From: [REDACTED]
Sent: 30 June 2022 09:49
To: Planning
Subject: PLANNING APPLICATION 3/2022/0449

RE LOWER ABBOTT HOUSE

We have already submitted our response regarding this latest planning application. One of our main objections was the proposed raising of the ridge height of this property by one metre.

PL.11

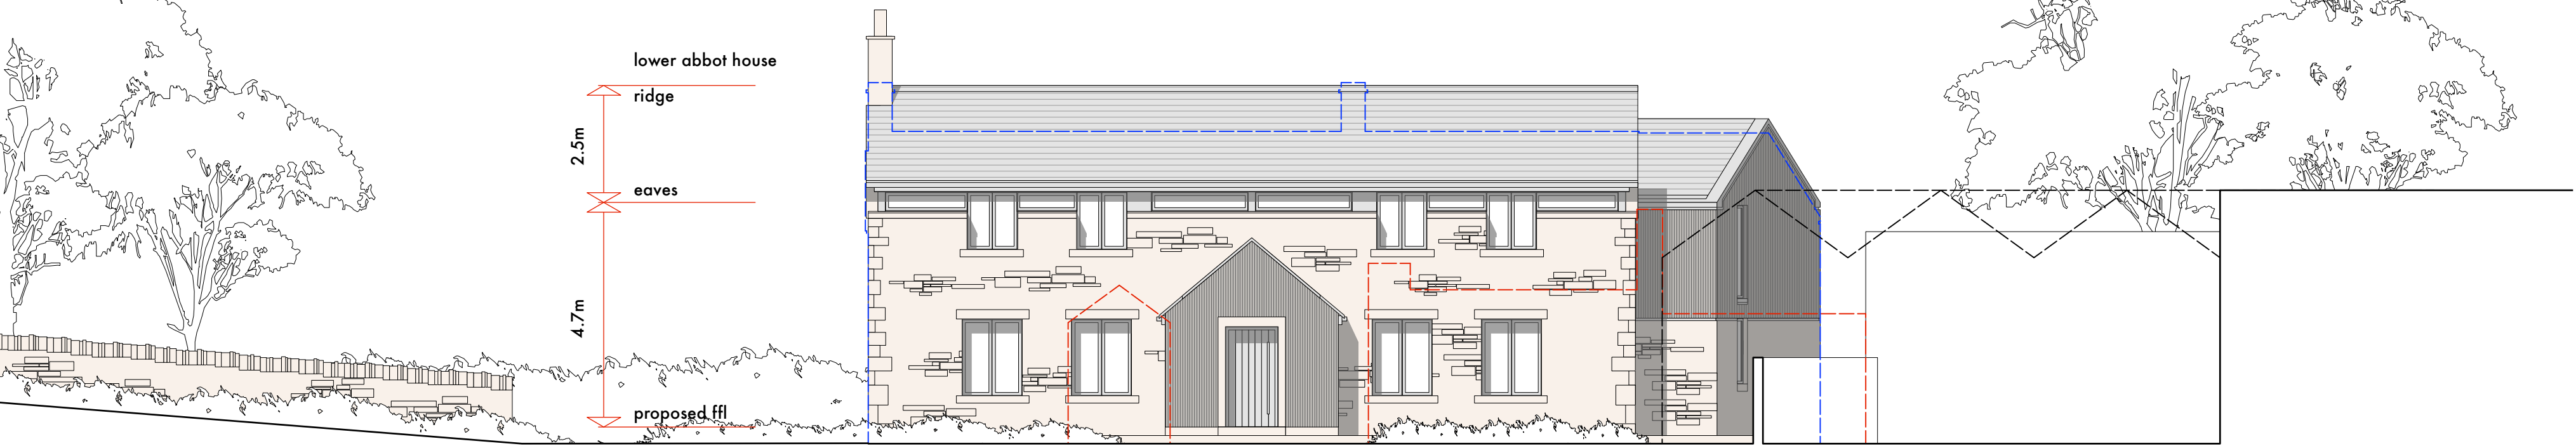
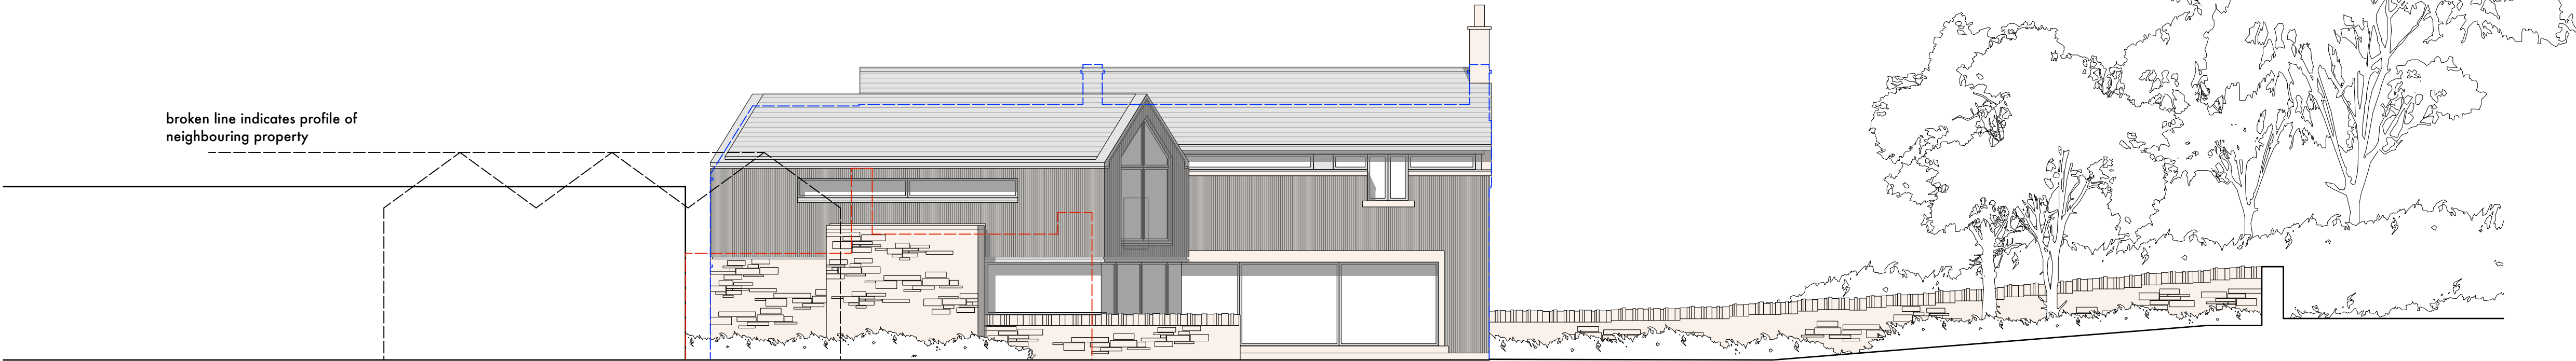
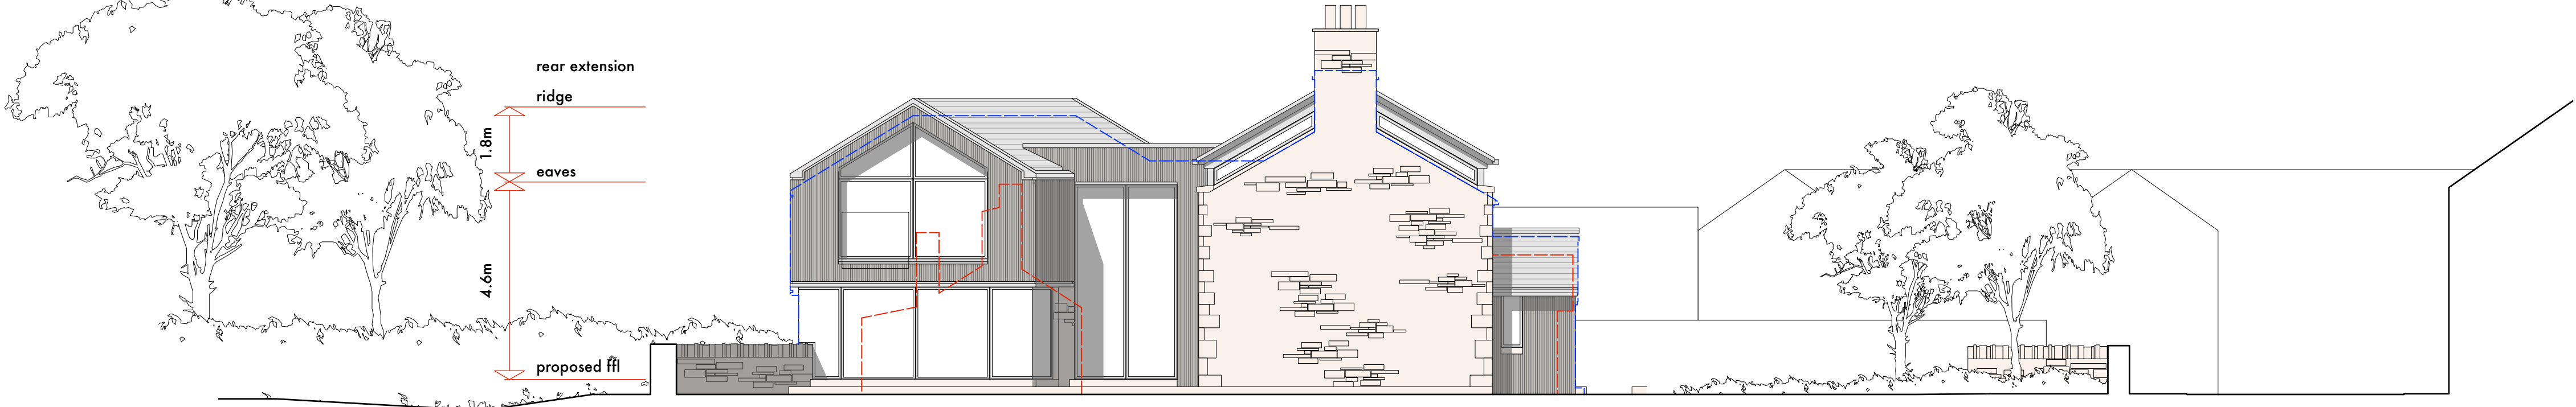
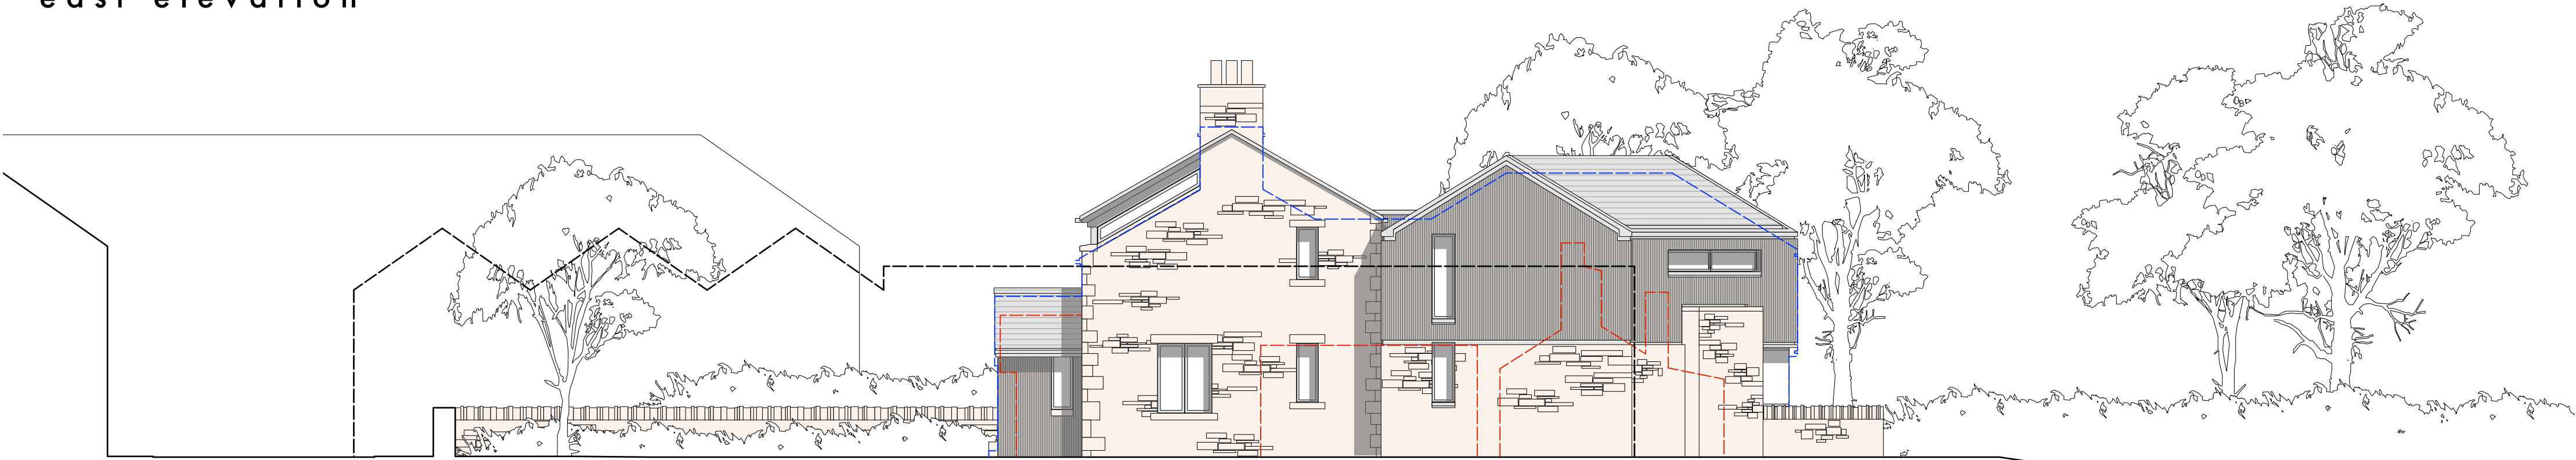
The recently published press feature (please see below), which has been rejected by Planning Inspectors, highlights our concerns that this would not be in keeping with other historical properties in the area and could lead to precedents being taken.
